Please upload the attached revised plans and letter sand the email below from the applicant onto Ocella for WA/94/19/NMA, WA/95/19/DOC and WA/96/19/DOC - Land East of Tye Lane, Walberton.

Drawing No: CSA/3823/108

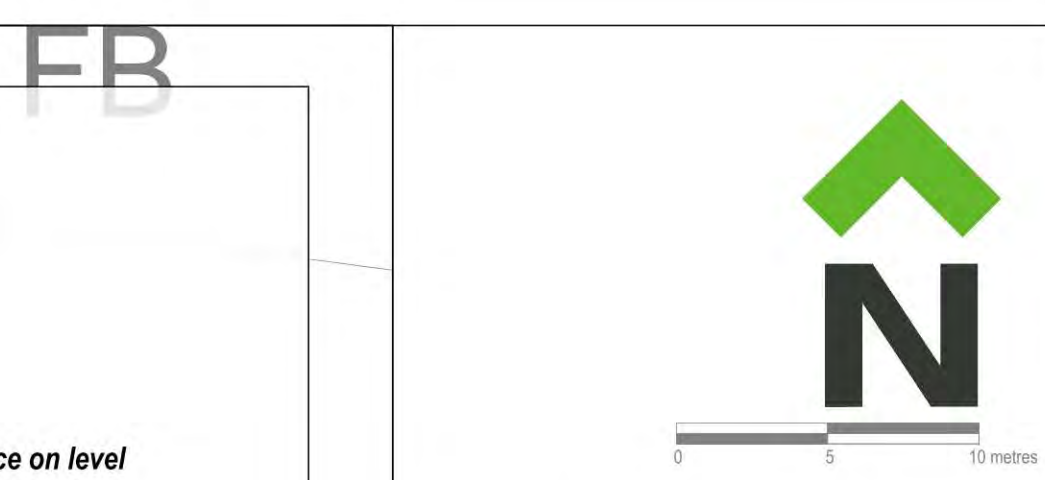
Please find attached a document which includes 4 annotated Public Open Space Plans identifying additional landscaping along the northern boundary of the site with Avisford Park Golf Course.

Could the additional planting be shown on all of the Public Open Space and landscaping plans and be submitted as a matter of urgency for **WA/94/19/NMA**, **WA/95/19/DOC** and **WA/96/19/DOC** - Land East of Tye Lane, Walberton.

As per our discussion, please find attached the revised landscaping plans with additional planting located in the areas highlighted in your email below. We have sought to increase the landscaping as far as we can in these areas noting the construction requirements to be careful of landscaping in proximity to the dwellings as well as continuing to allow connectivity around the site. We have proposed planting which is consistent with the existing approved planting species and mix.
